Consultation Response from: KC Environmental Health (Pollution & Noise Control)
2023/92700 Land at, Whitley Road, Whitley, Dewsbury, WF12 0LZ
Reserved matters application for erection of one dwelling pursuant to outline permission 2020/93432 (APP/Z4718/W/21/3274396) for erection of residential development
Date Responded:
18th December 2023
Responding Officer:
RM
Responding Ref:
WK/202338114

The following comments relate to Plot 2 only of the outline permission 2020/93432 (APP/Z4718/W/21/3274396) for erection of residential development.

SITE / GROUND FLOOR PLAN

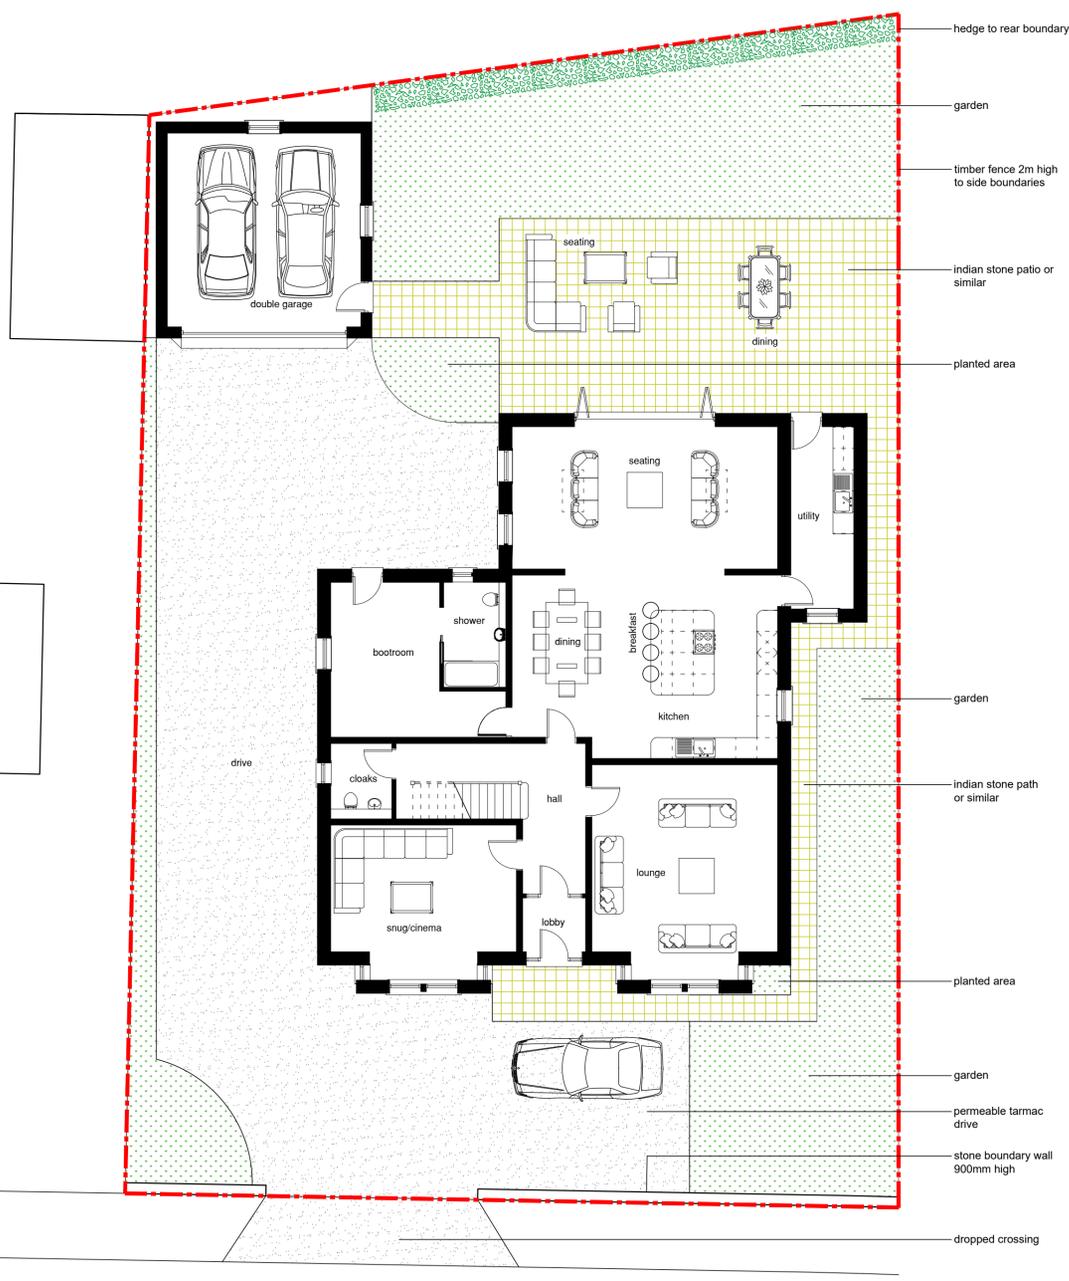
From the information provided the proposals include the provision for 2no. car parking spaces. In an application of this nature, it is expected that facilities for charging electric vehicles and other ultra-low emission vehicles are provided in accordance with the National Planning Policy Framework and Air Quality & Emissions Technical Planning Guidance from the West Yorkshire Low Emissions Strategy Group. No information has been submitted therefore, condition 8 of the outline application 2020/93432 must remain.
